Addendum No. 1

**Pine Tree Shopping Center
Retail Redevelopment**

**1030 Brighton Avenue
Portland, Maine**

2/24/05

M-2

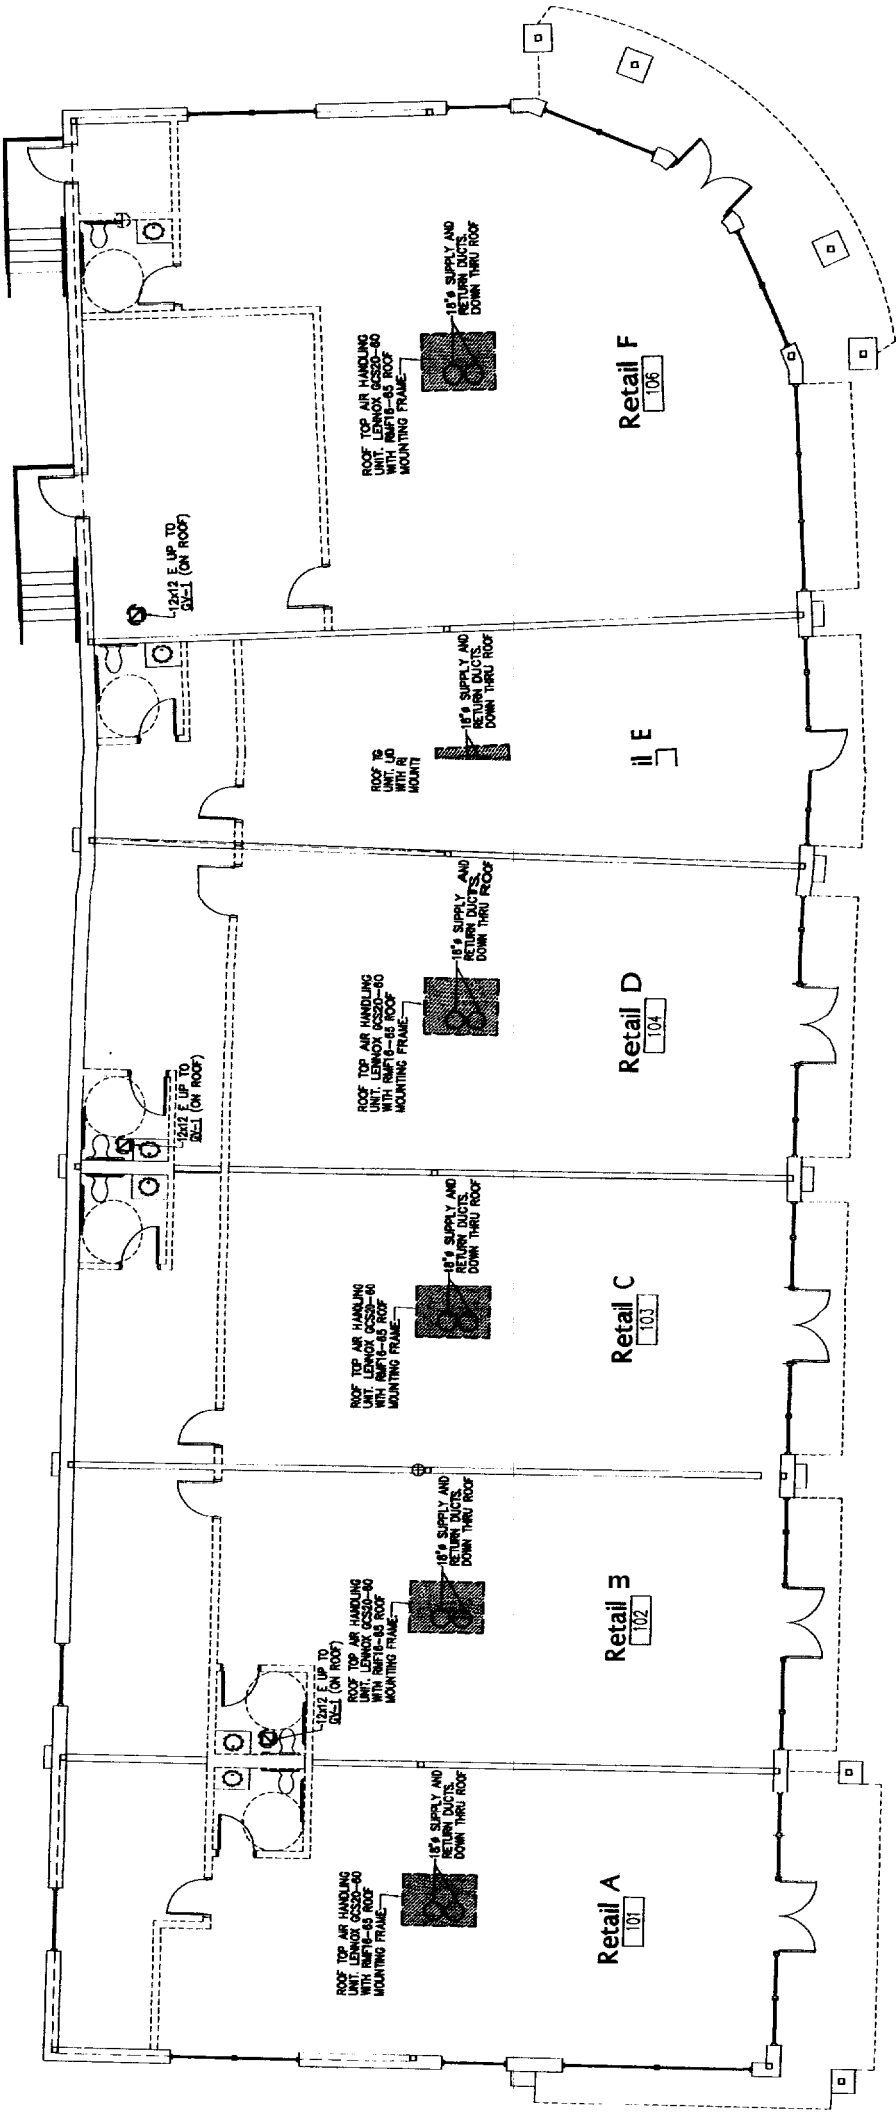
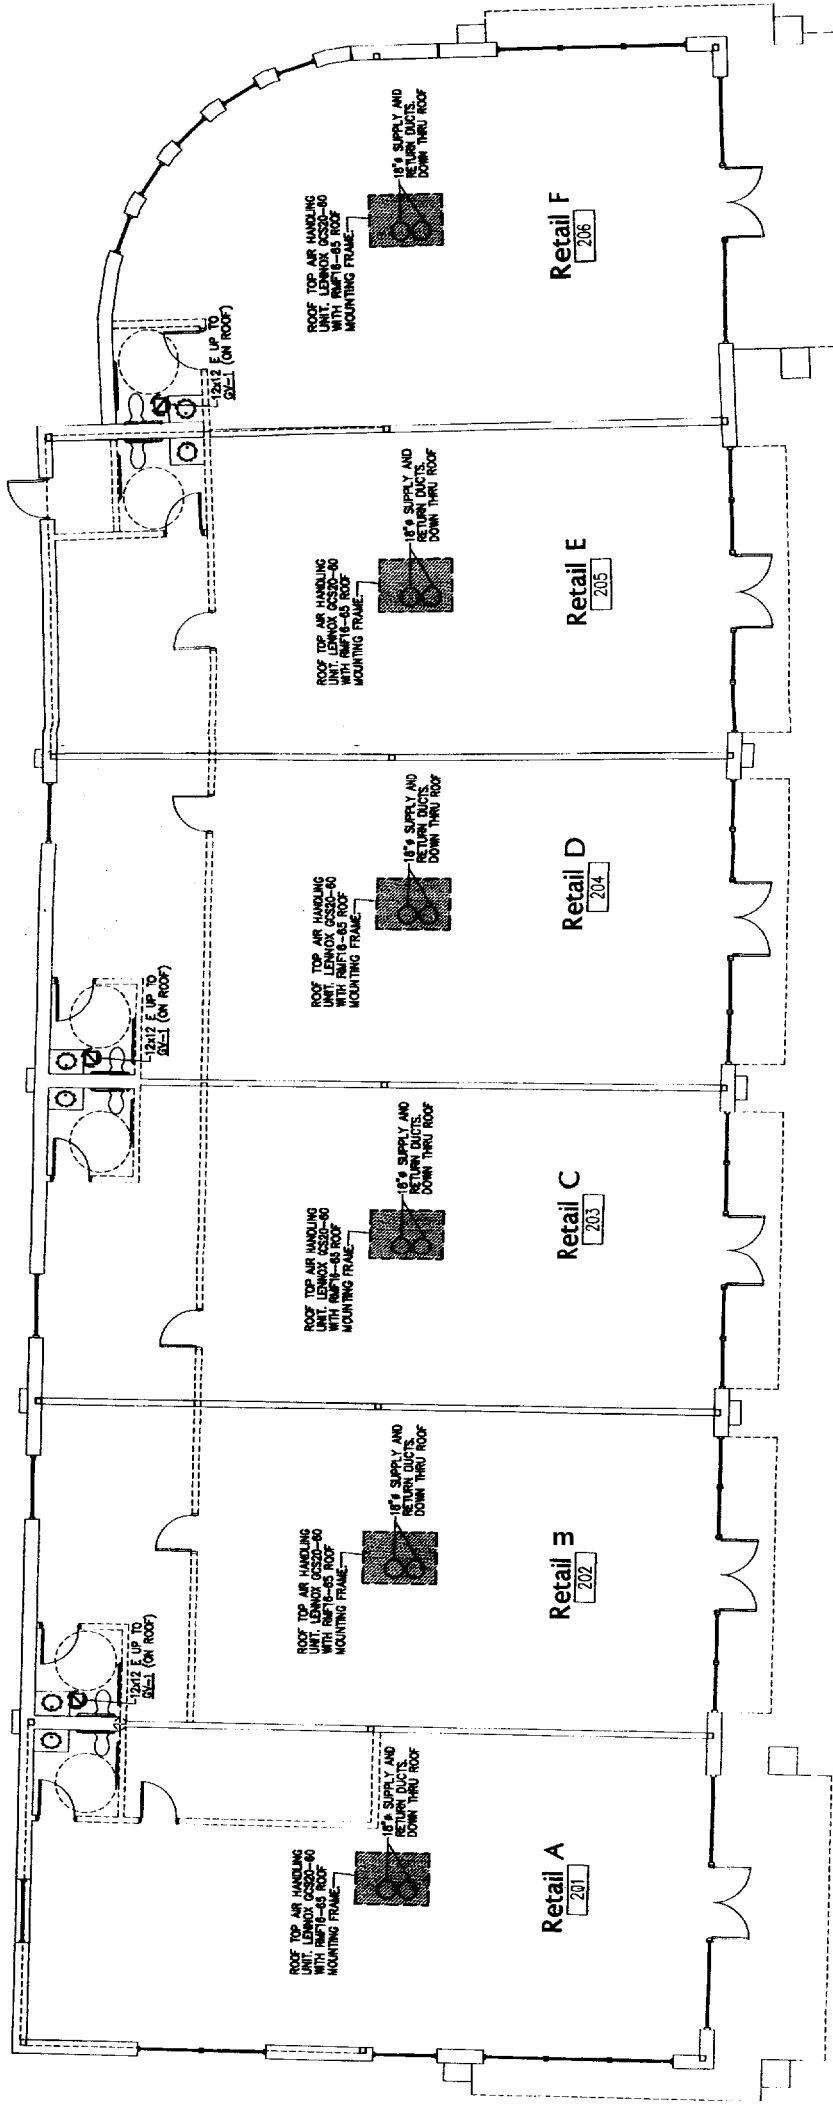
- Item 5. Drawings A2.1 and A2.2: ADD the following Note: "Refer to drawing M-2 for gravity vent locations, 3 locations each building. Refer to 1/M-1 for vent flashing detail."
